**KIRKLEES METROPOLITAN COUNCIL
INVESTMENT & REGENERATION SERVICE**

DELEGATED DECISION TO DETERMINE PLANNING APPLICATIONS

Reference No:	2024/62/93001/E
Site Address:	Land Adjacent, 38, Upper Road, Dewsbury, WF17 7LT
Description:	Erection of dwelling
Recommending Officer:	Edward Cheseldine

DECISION - REFUSED

PROPOSED HOUSE
ADJACENT
38 UPPER ROAD
BATLEY CARR

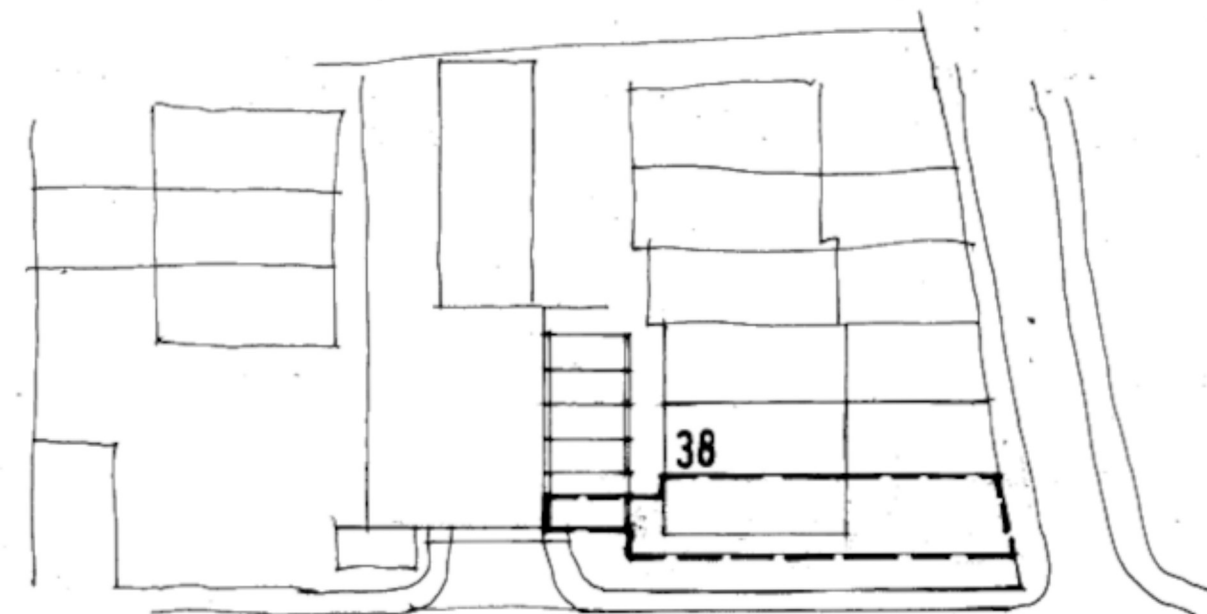
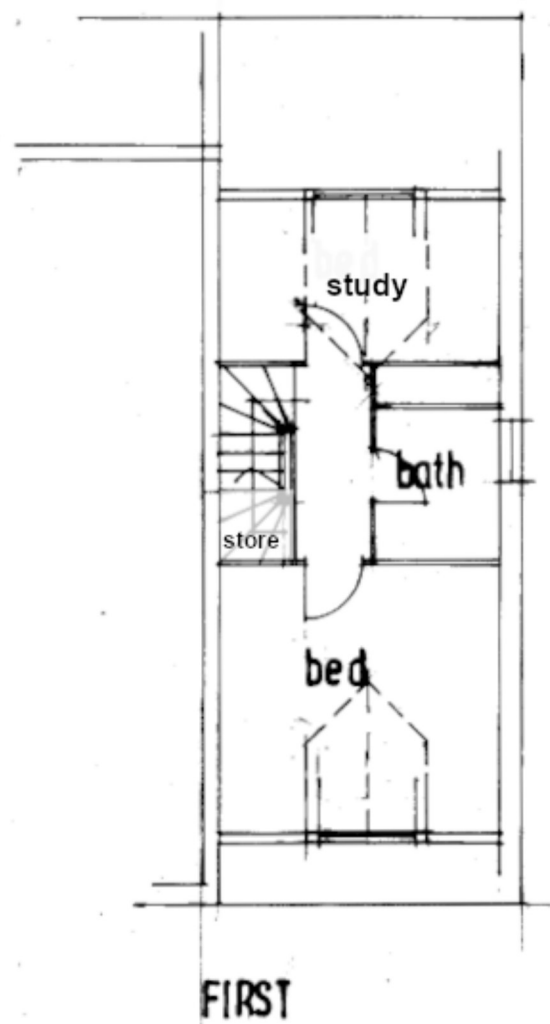
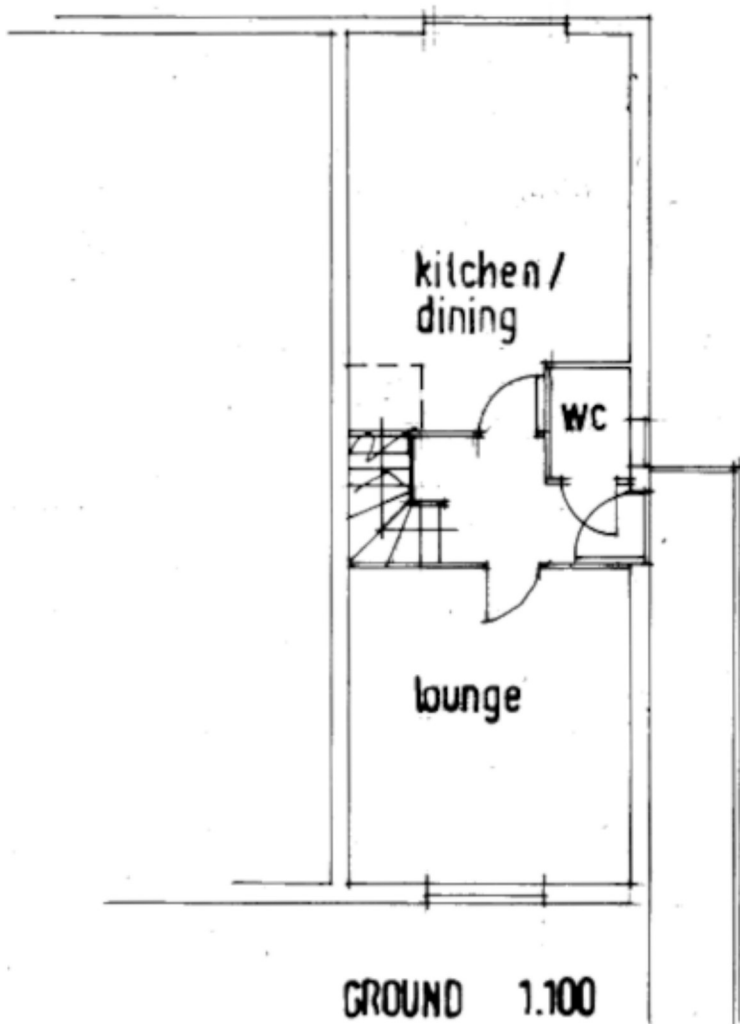
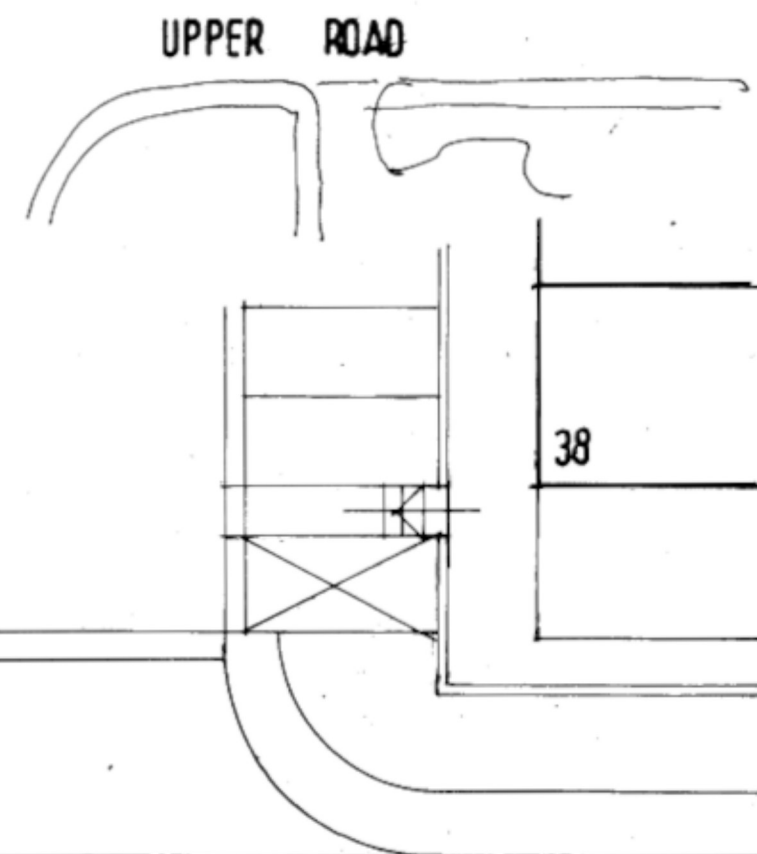
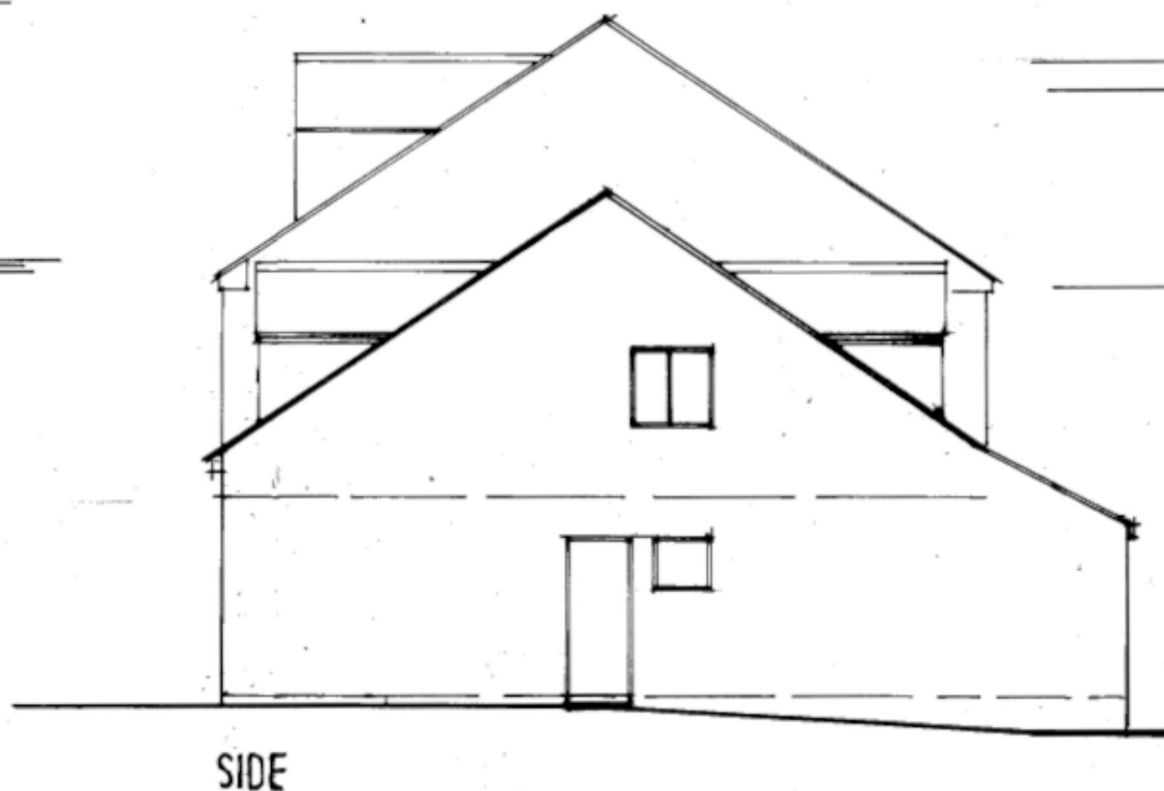
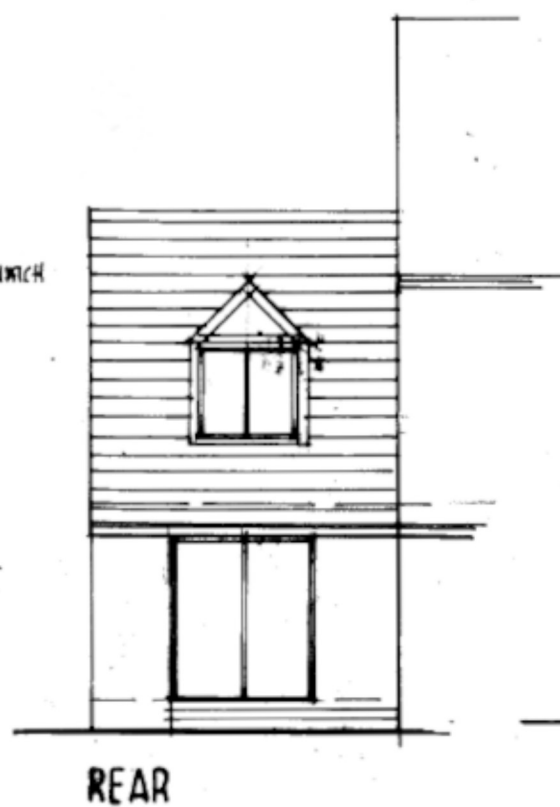
In terms of the impact of the proposed development, due to the scale, massing and ridgeline height, the extension would obstruct visibility of a significant proportion of the listed building including its buttresses and a high proportion of the tower. Due to the setback approach of the listed building, the perspectives at these points cut across the existing buffer space between No. 38 and the public footpath. Considering the height and ridgeline of the proposed dwelling, the view of the building will be obscured, blocking the main architectural features which provide the setting and enjoyment of the listed building for the public when observed from the east of the church.

The building is set down from the adjoining dwelling, it is single storey attached to a row of two-storey dwellings. There are no other buildings in the immediate vicinity with a similar appearance. Due to its location on a prominent corner plot, it will be highly noticeable from the roadside. The change in scale fails to follow the overall established building form and character of the area. The proposed dwelling is only 4.00m in width. Given the relative scale of the property, with its position, set against the two-storey dwelling, the proposed building will appear contrived within its plot giving a cramped appearance which is contrary to the existing building group.

Notwithstanding the scale of the building, openings on the front and rear of the building are similar in placement and size to other dwellings on the building row. The building rests on a corner plot location, the side elevation does not relate well to the streetscene as there is no active frontage design. It would be requested that high level windows are introduced to provide street interaction if the application was set for an approval. Given the prominent setting, the appearance of the side elevation does not maintain or enhance the character of the area which is unsatisfactory in terms of design.

In terms of roofline, a pitched roof has been chosen in an orientation of the other buildings to the north. As previously discussed, whilst the orientation matched the terrace row, the height of the structure will present a stepped down approach which does not accord within the building group to the north.

1. The proposed development would result in harm to the setting of the designated heritage asset (Holy Trinity Church), which provides important visual and social benefits to the wider area, with no public benefits to outweigh such harm. It would obstruct important vistas from Upper Road, whilst enclosing the listed building's surrounding due to the continuation of development. To permit the extension would be contrary to Policies LP24 and LP35 of the Kirklees Local Plan and Chapter 16 of the National Planning Policy Framework

2. The proposed development, due to scale and positioning would have a detrimental impact within the streetscene, reducing the sense of openness within this section of Upper Road, whilst appearing incongruent within the building group due to its architectural features. This would be contrary to Principle 2, 5, 14 & 15 of the Housebuilders Design Guide Supplementary Planning Document, Policy LP24(a) of the Kirklees Local Plan and Chapter 12 of the NPPF.
